ENG-SF20015-R3-Plat-redlines.pdf Markup Summary

Subject: Callout
Page Index: 1
Date: 6/17/2021 3:10:44 PM
Author: dsdrice
Color: ■
Layer:
Space:
Page Label: [1] 2518801FP-COVER 1

STERLING RANCH FILING NO. 2

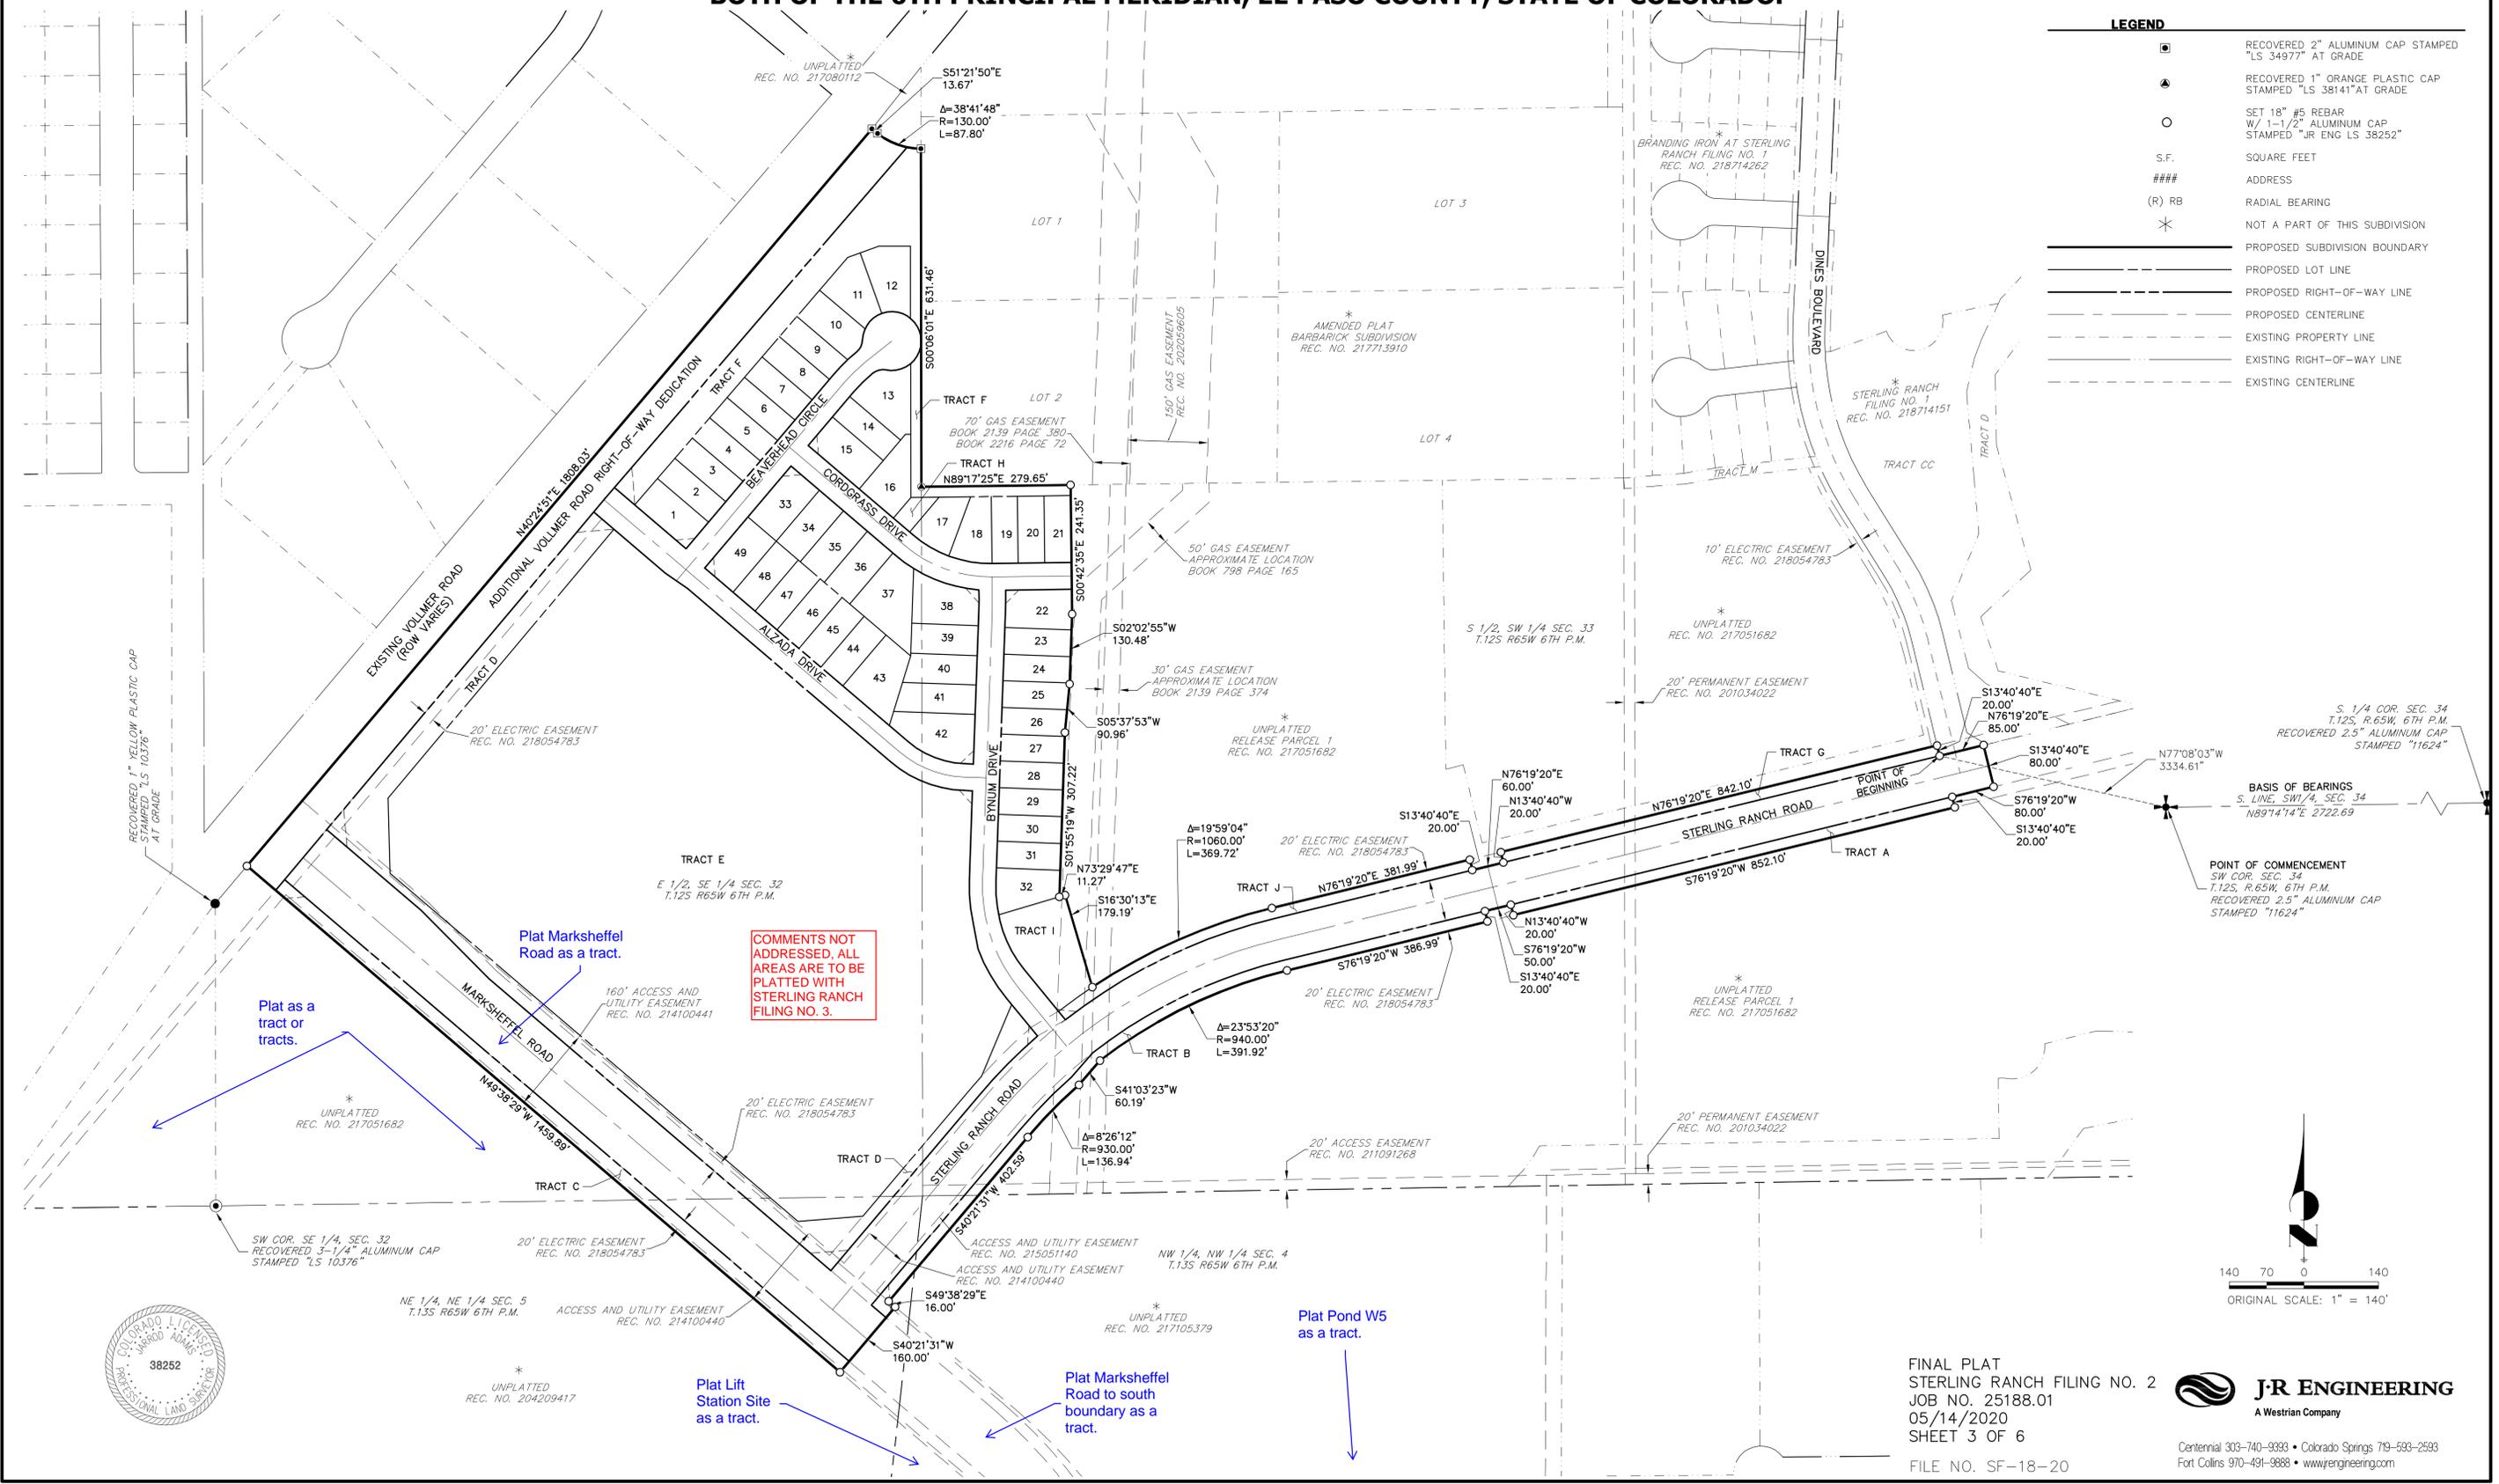
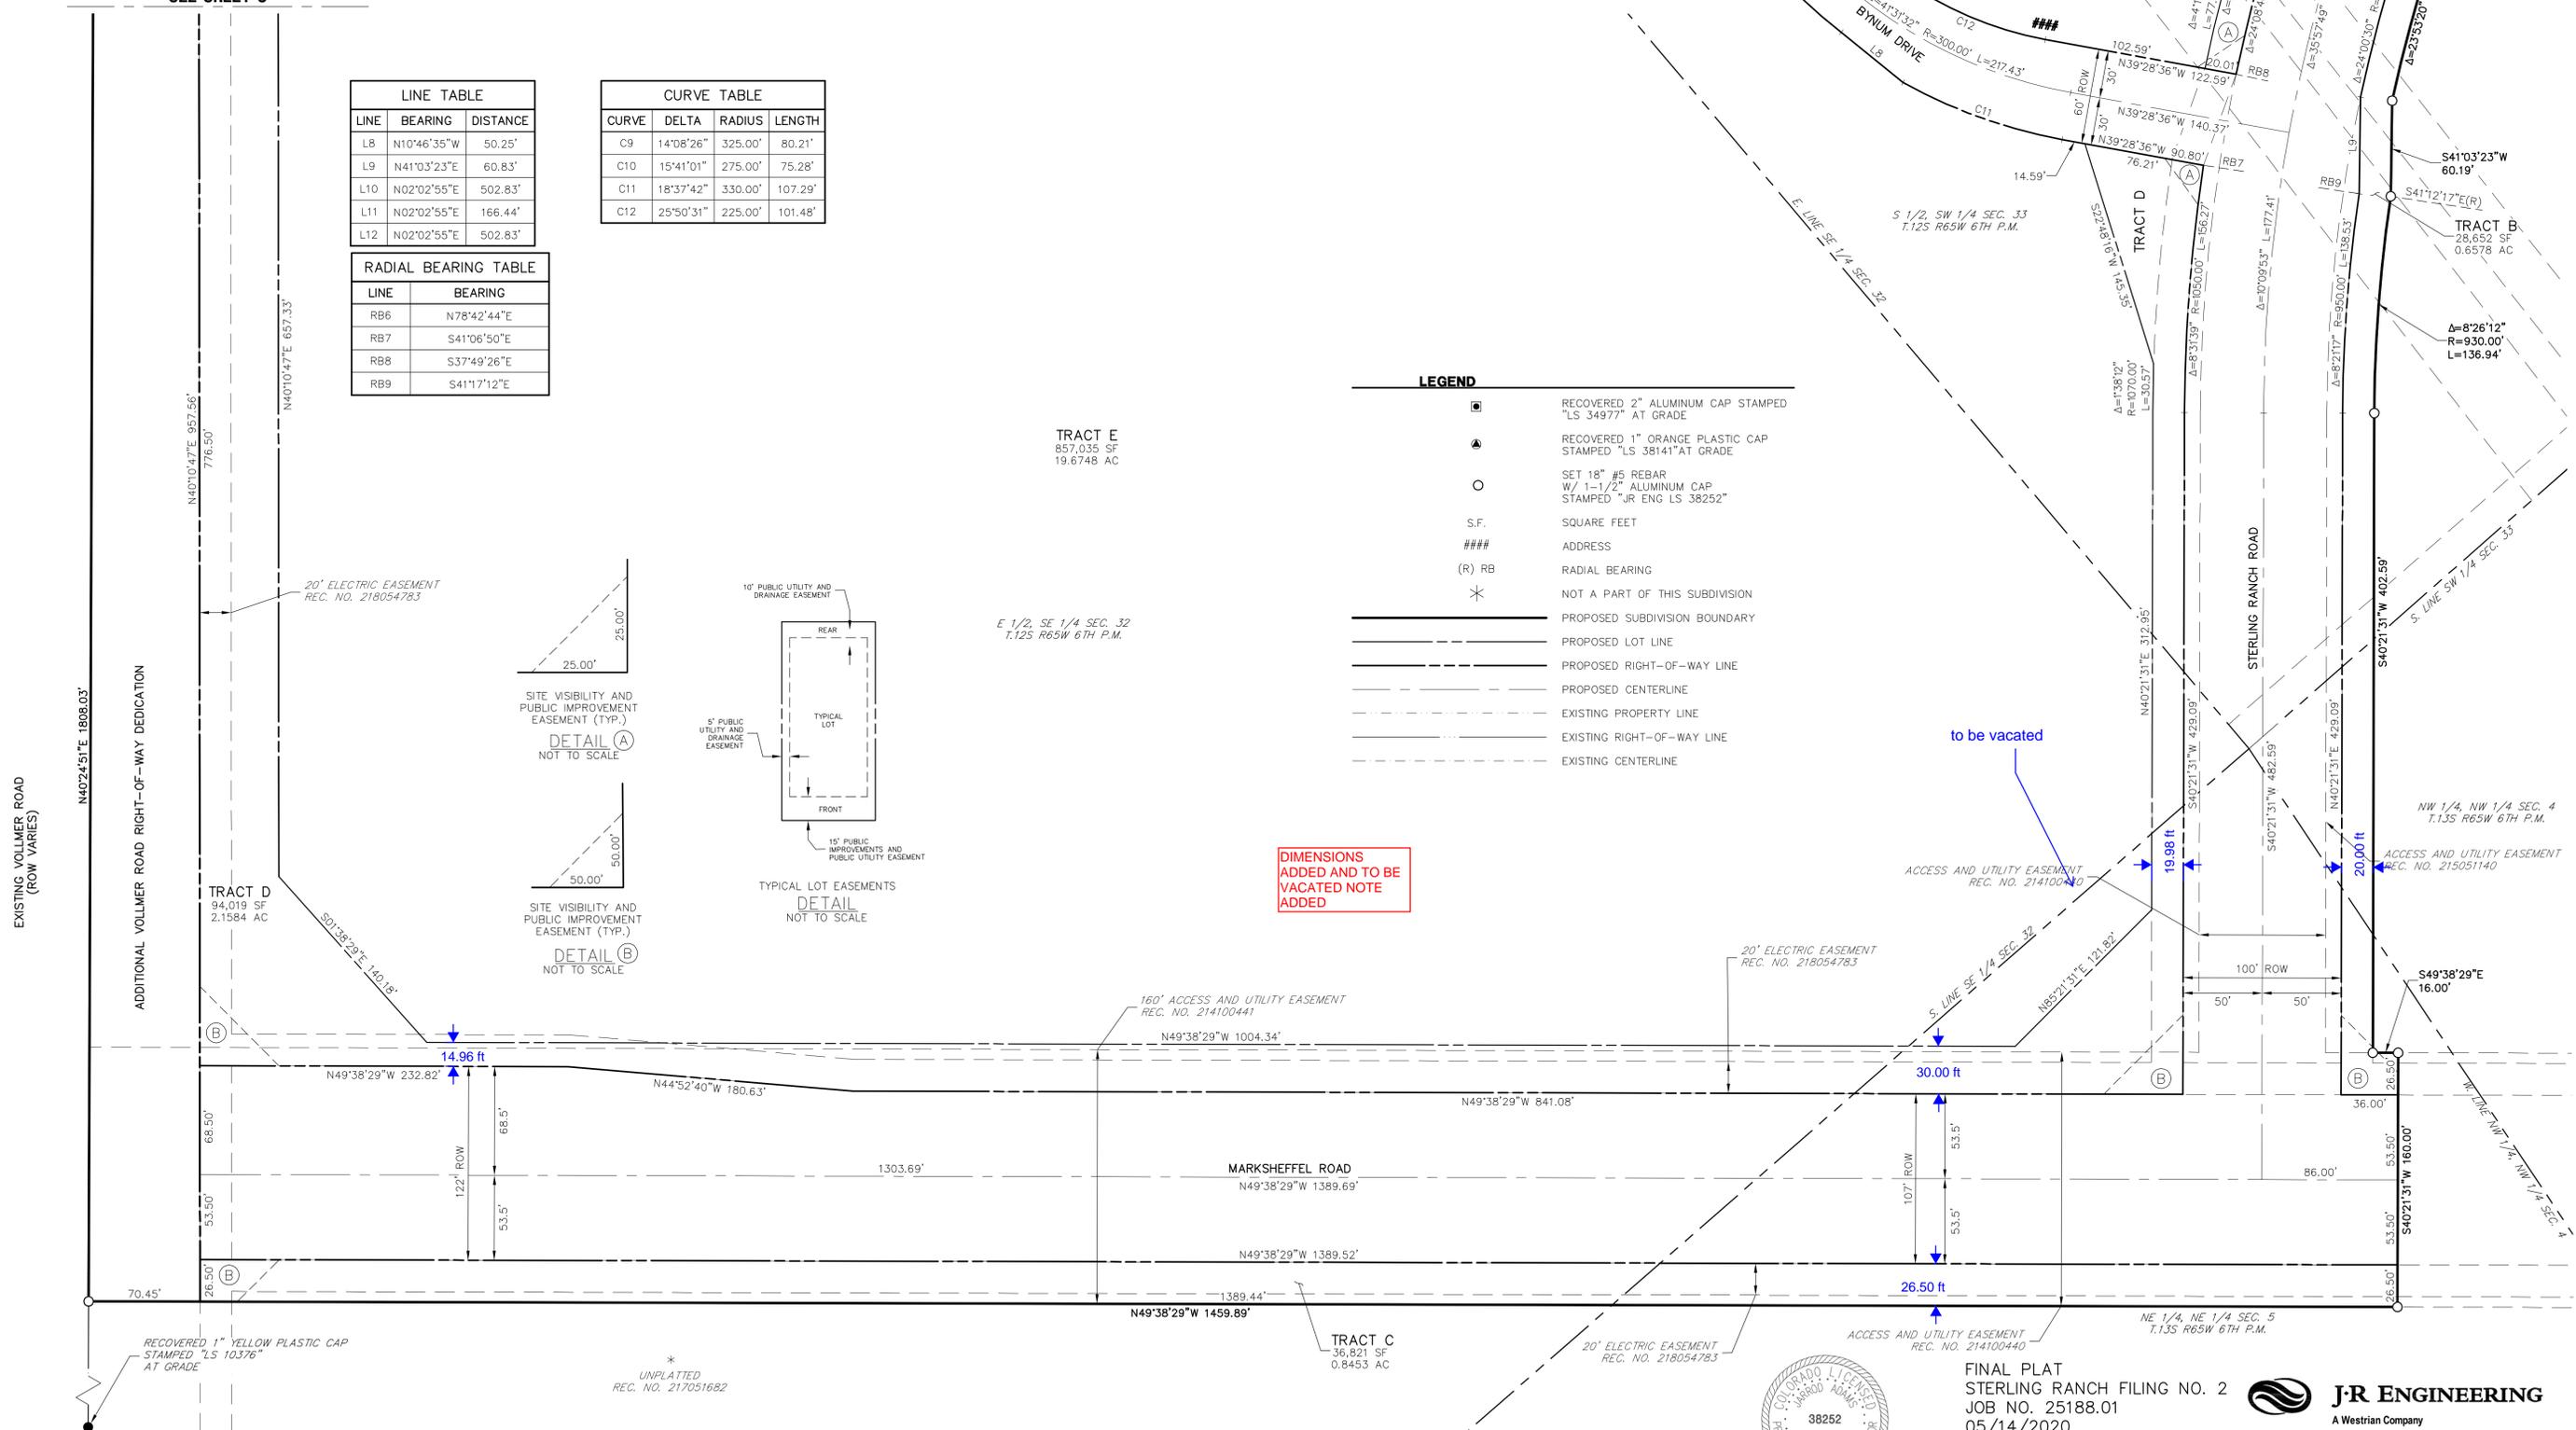
Plat south portion of Marksheffel Road (and the necessary ROW for Vollmer Rd. to avoid a ROW plat) as tracts.

Is Pond W5 tract being platted with Marksheffel Road?
